# CITY OF ALBUQUERQUE

PLANNING DEPARTMENT – Development Review Services

June 4, 2014

**RE: Pacific Mutual Door and Window - Tract 1, Lands of L.A.  
Paving, Grading & Drainage Plan  
Engineer's Stamp Date 4-29-2014 (File: C17D005)**

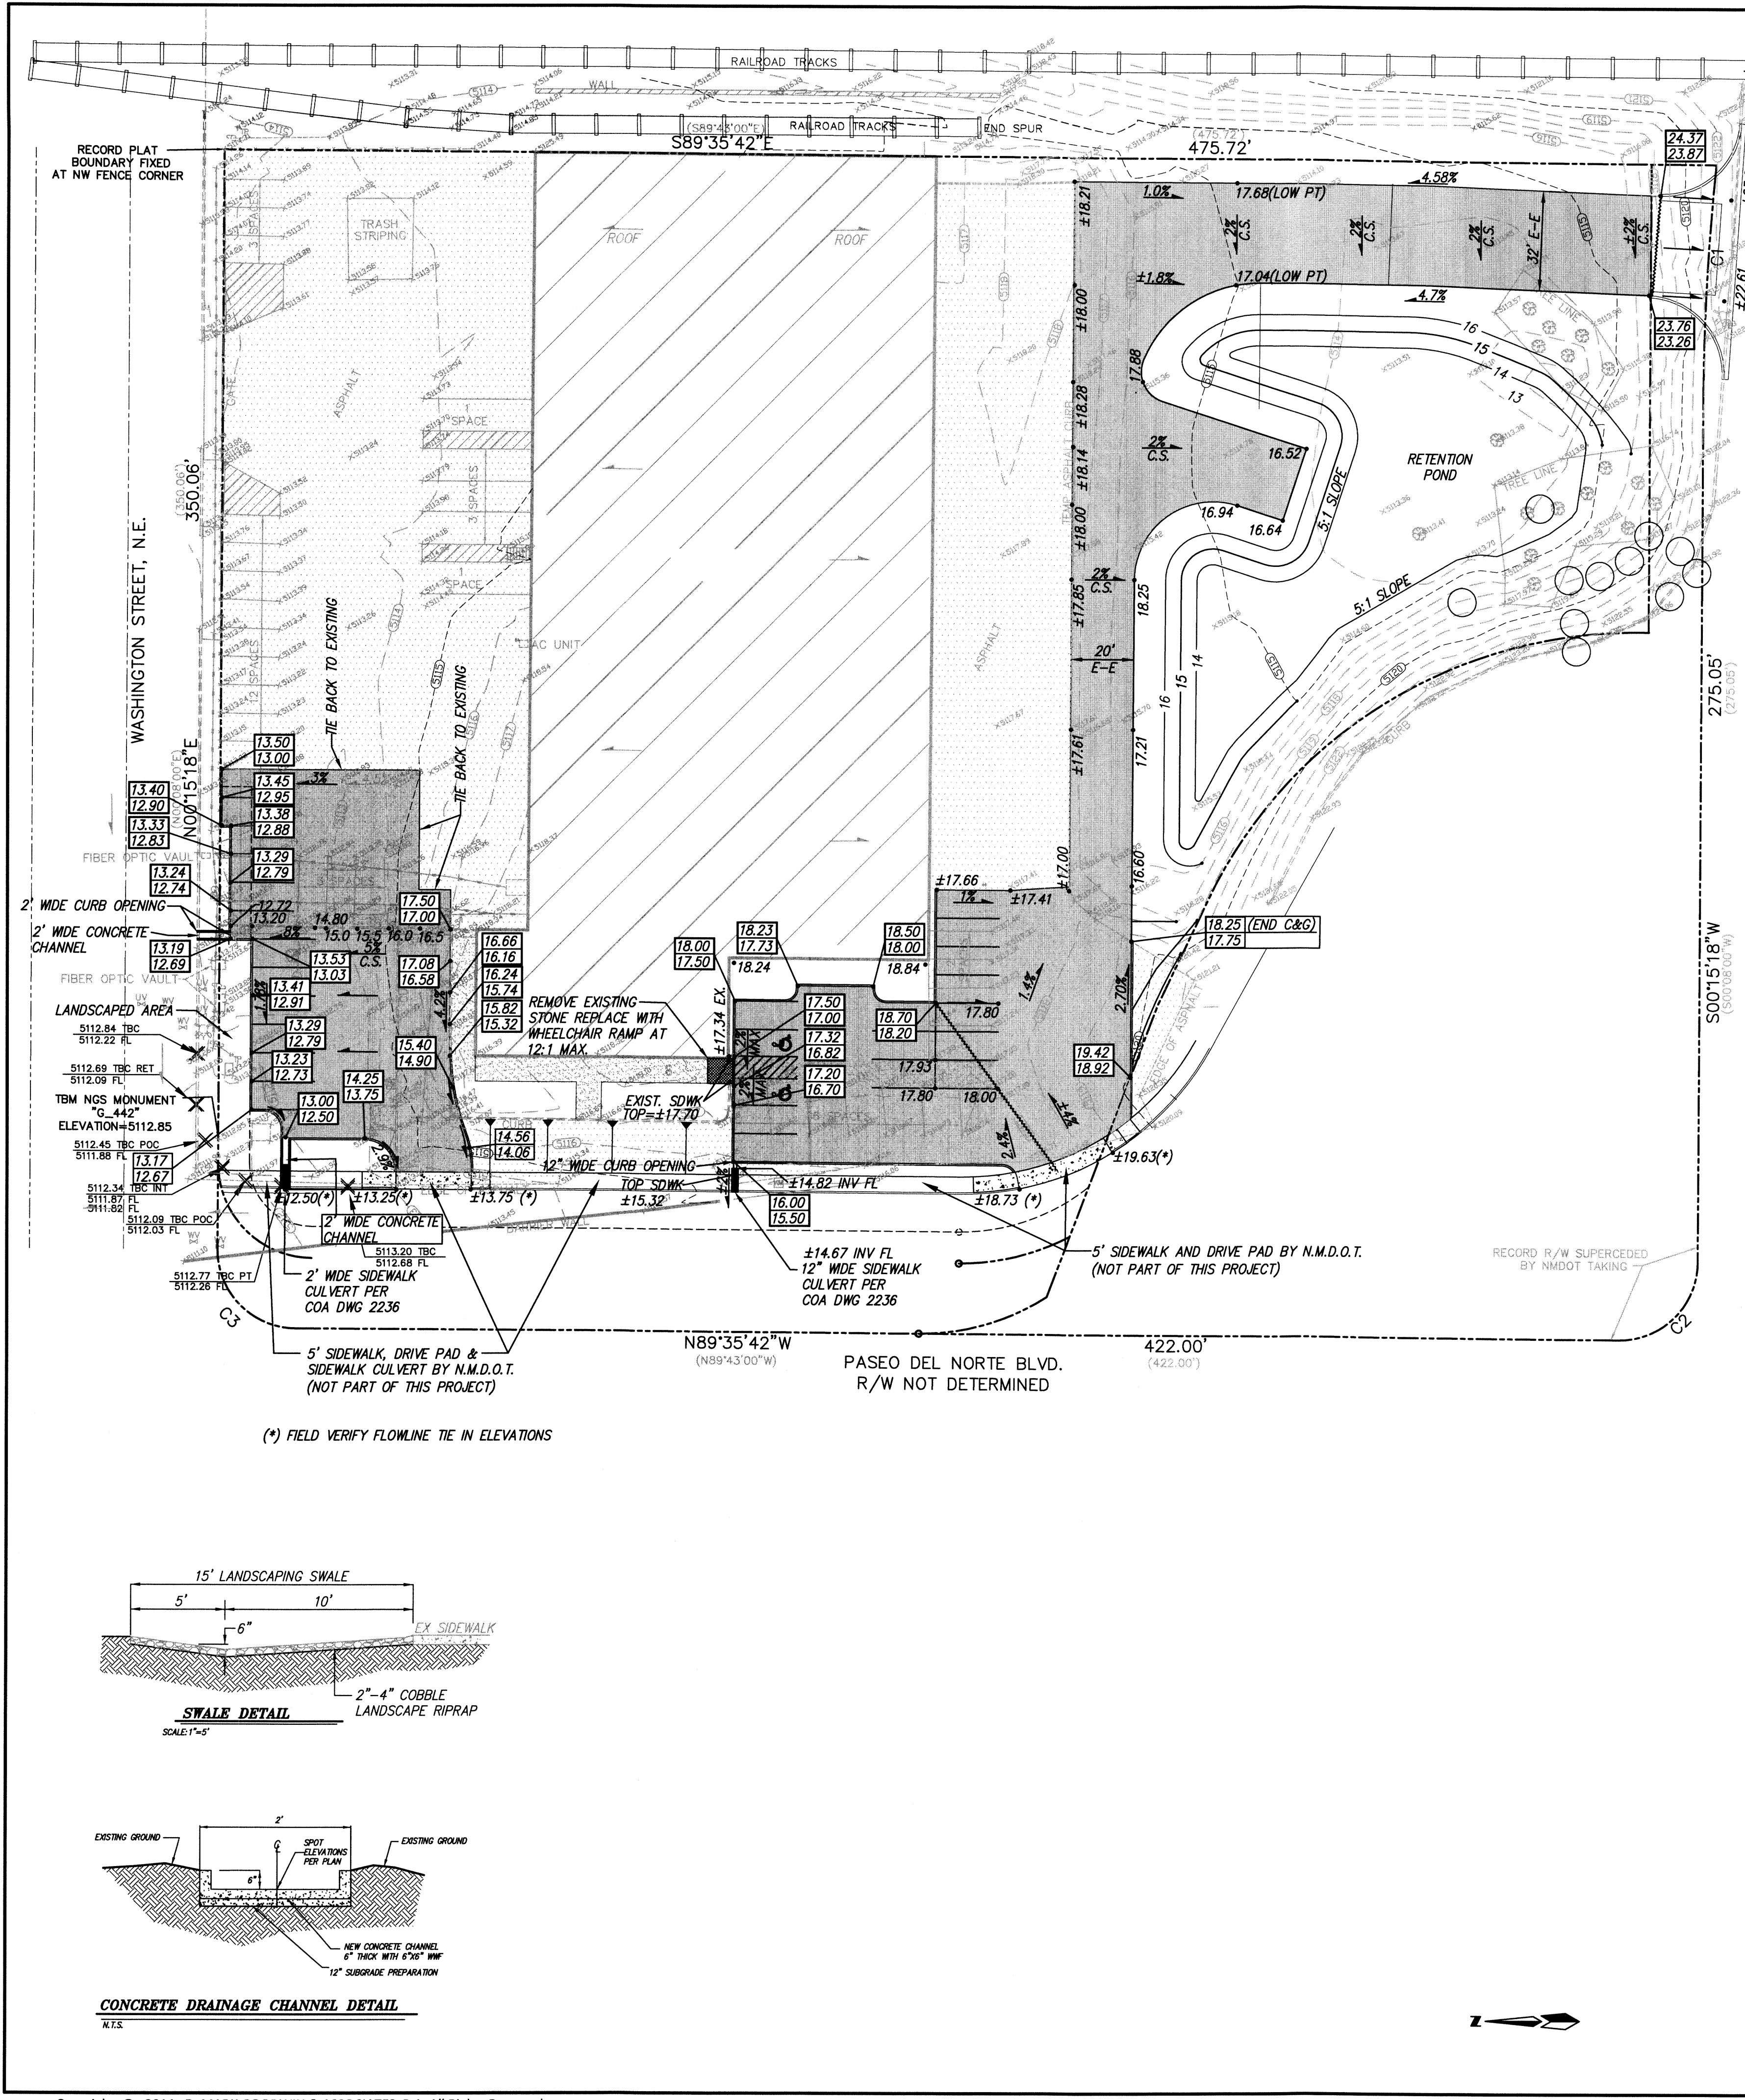
1. Indicate the Emergency overflow path as discussed – through the swale along the south side of property.
